**Snapper Mineral Sands Project (06_0168 MOD 5)
Exhibition of Environmental Assessment**

NSW Trade & Investment, Regional Infrastructure & Services, Division of Resources & Energy (DRE) has reviewed the *Snapper Mine Production Increase Modification Environmental Assessment, August 2014*.

Figure 7: Mining options 1 (existing), 2 and 3

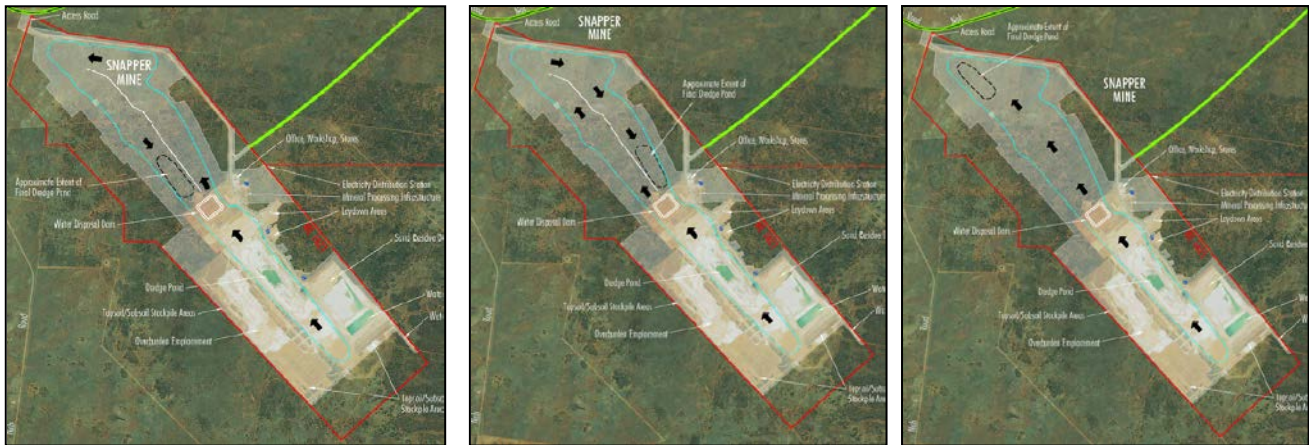
1. The three mining options proposed do not specify a final location for the dredge pond and final depression post mining.
